DEVELOPMENT REVIEW BOARD - HYDROLOGY SECTION
 Ernest Armijo, P.E., Principal Engineer 924-3986 earmijo@cabq.gov

DRB Project Number: <u>2019-002046</u>		Hearing Date: <u>2-26-2020</u>	
Project: <u>SWMD Admin & Maintain, Edith</u>		Agenda Item No: <u>2</u>	
<input type="checkbox"/> Sketch Plat	<input type="checkbox"/> Minor Preliminary / Final Plat	<input type="checkbox"/> Preliminary Plat	<input type="checkbox"/> Final Plat
<input type="checkbox"/> Temp Sidewalk Deferral	<input type="checkbox"/> Sidewalk Waiver/Variance	<input checked="" type="checkbox"/> Site Plan	<input type="checkbox"/> Bulk Land Plat
<input type="checkbox"/> SIA Extension	<input type="checkbox"/> DPM Variance	<input type="checkbox"/> Vacation of Public Easement	<input type="checkbox"/> Vacation of Public Right of Way

DECEMBER 10, 2019
SHEET No. SP-1

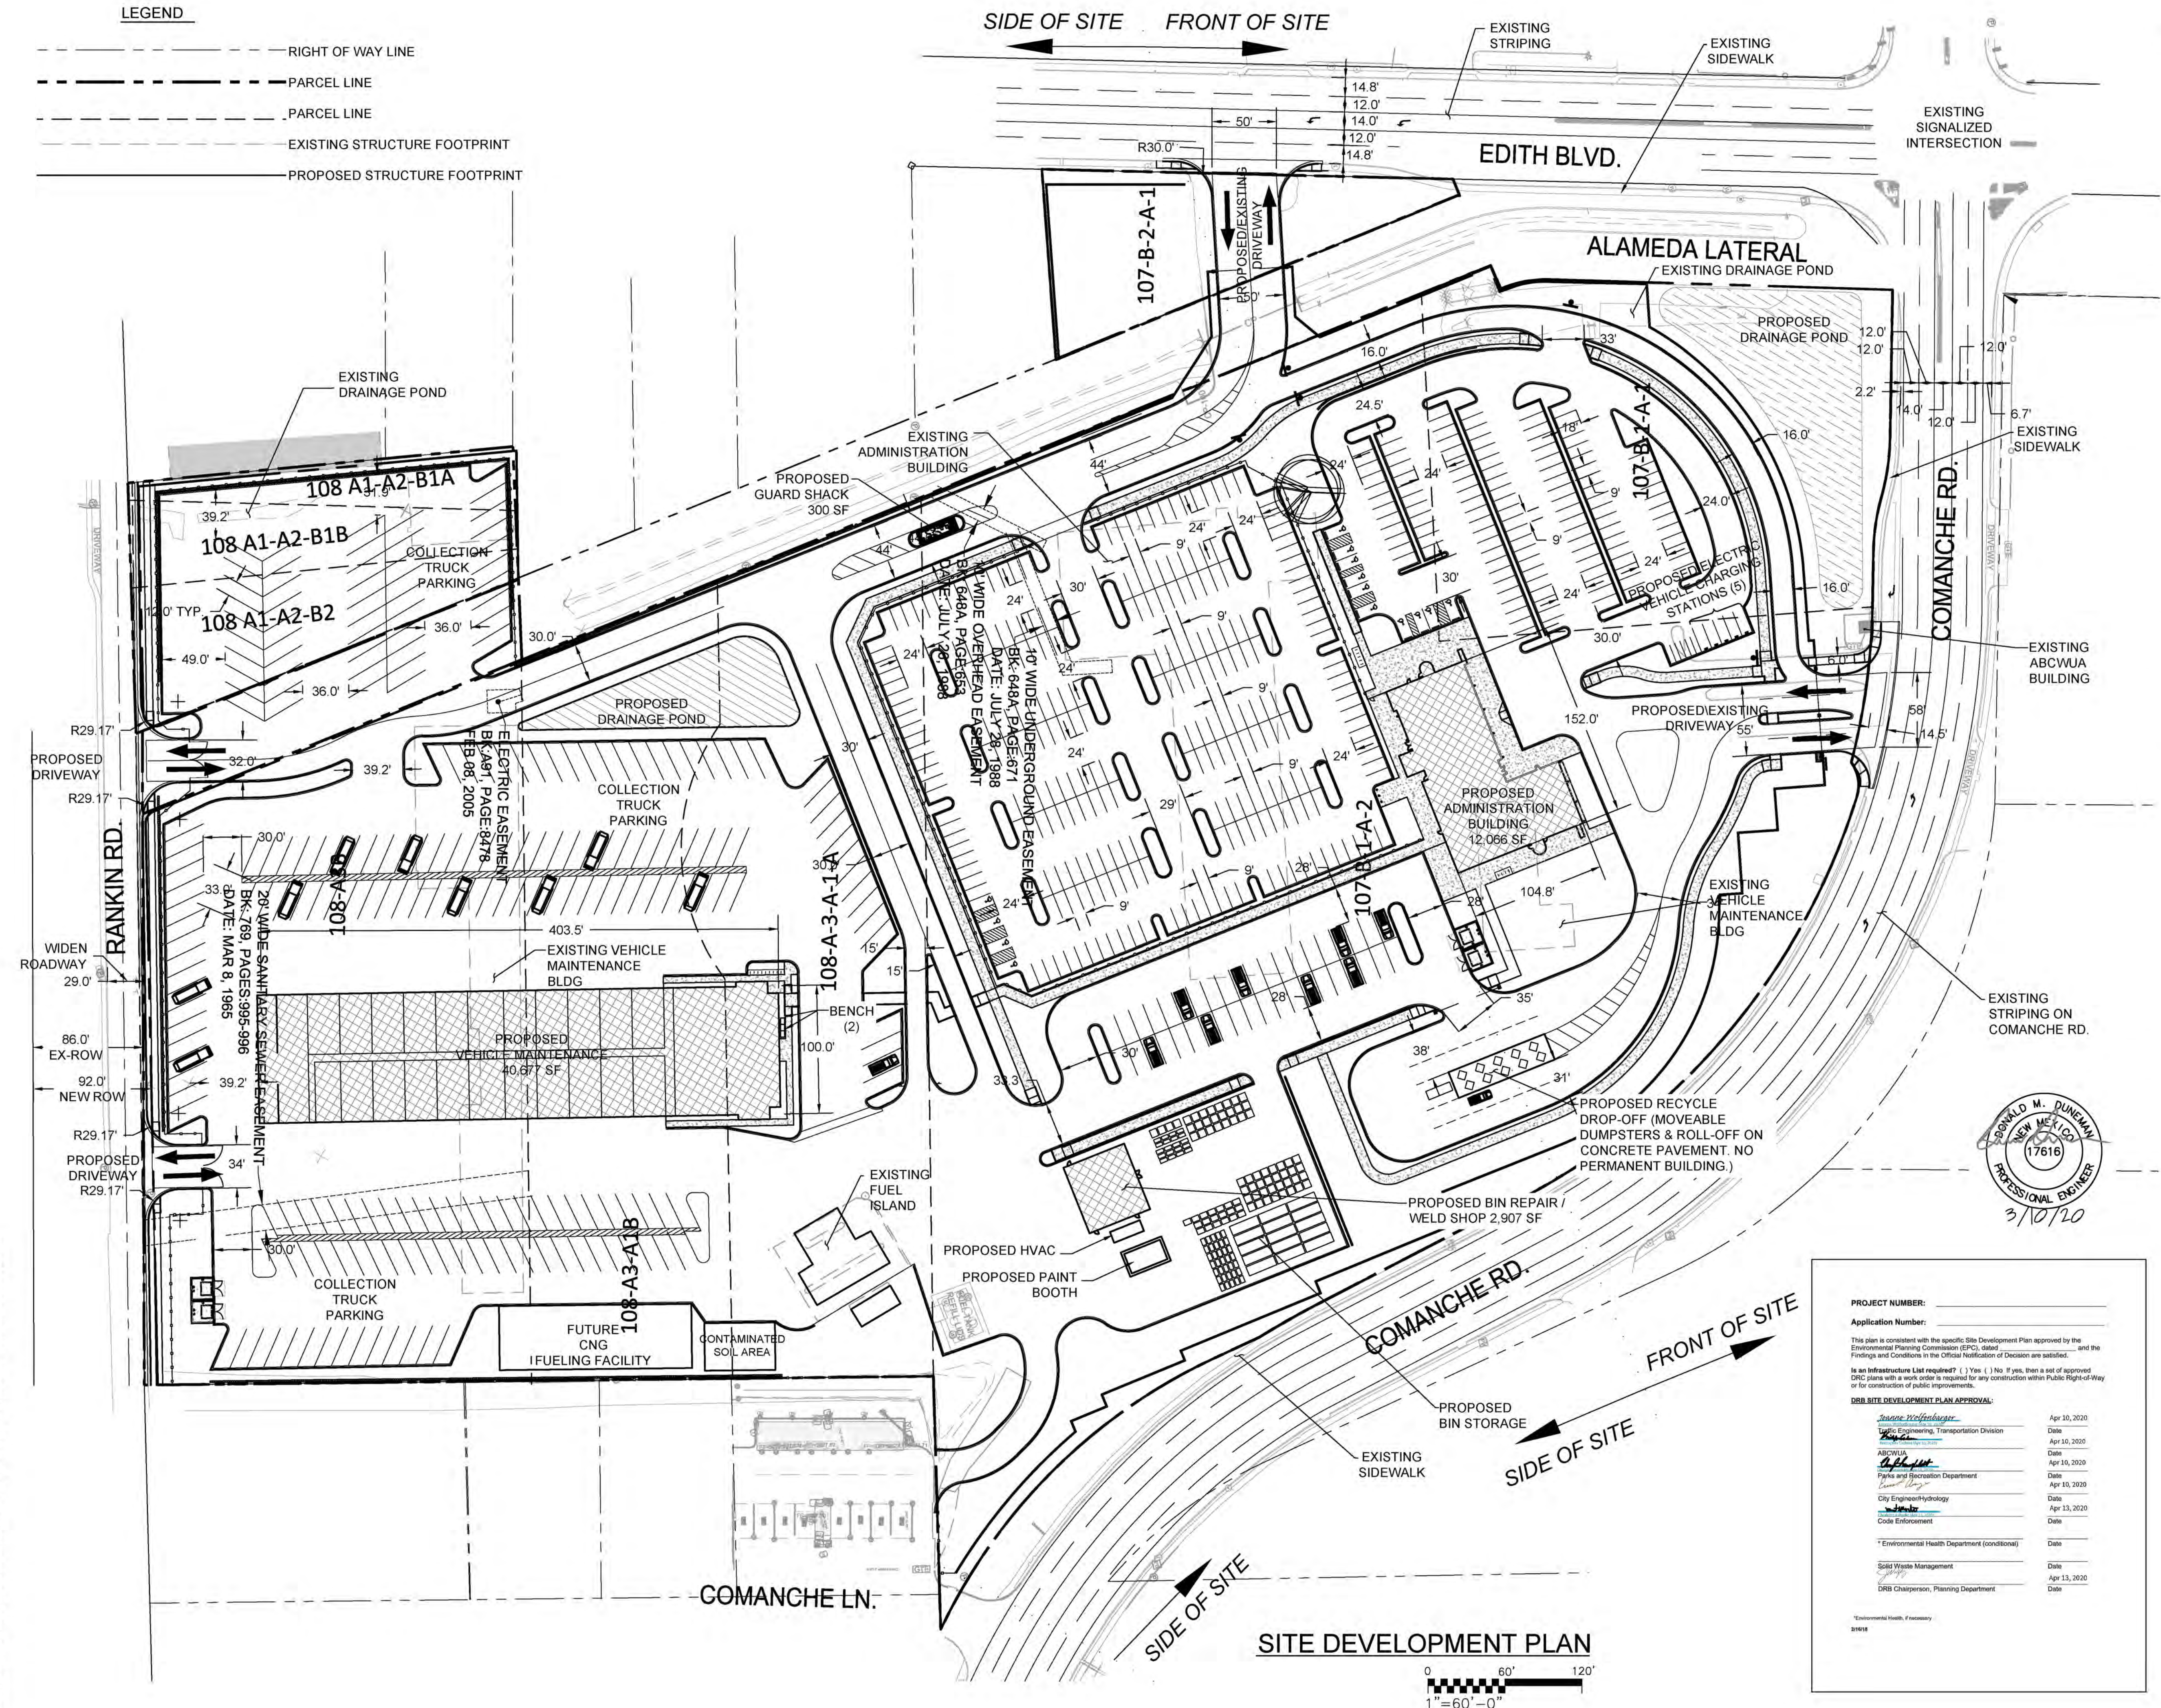
- An approved Conceptual G&D Plan is required. The last review was completed 5/28/2019 with no response yet.
- It appears that right of way dedication is needed along Rankin Rd. to contain the new C&G and Sidewalk. I see right of way on the Plat, but a width is not indicated other than along northerly lot lines which are not perpendicular to the dedication. Please show the dedication on the Site Plan and on the Plat listing the width.

ROADWAY TYPICAL SECTION - RANKIN RD.

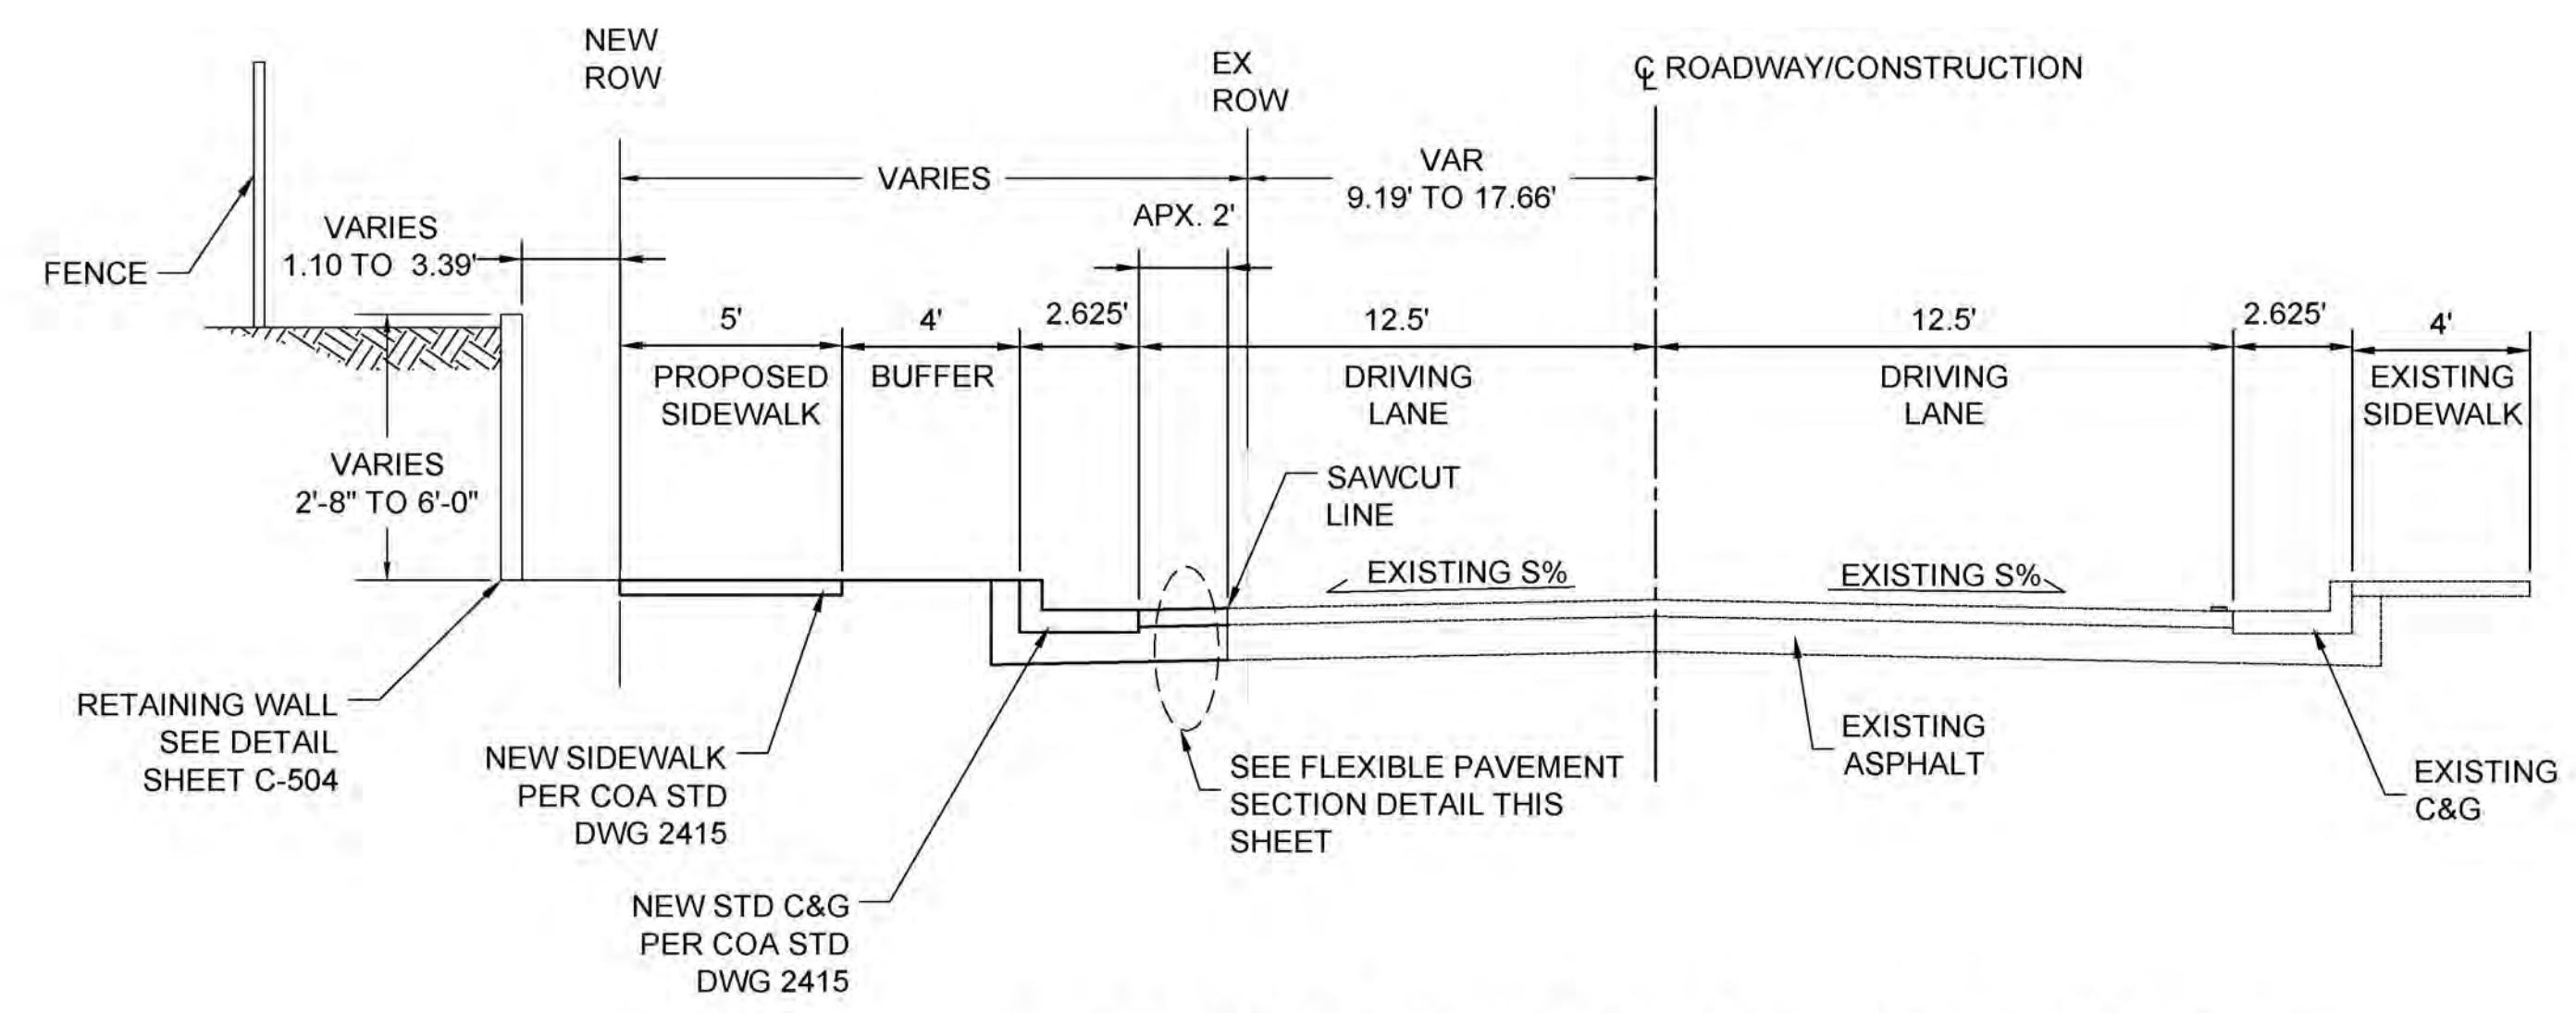
- Please provide a typical section of Rankin Road and include dimensions from the face of curb and sidewalk to the new right of way line. Also provide a typical section of the slope/retaining wall at the west end of the Rankin Rd frontage showing a stable slope between the sidewalk and parking lot.
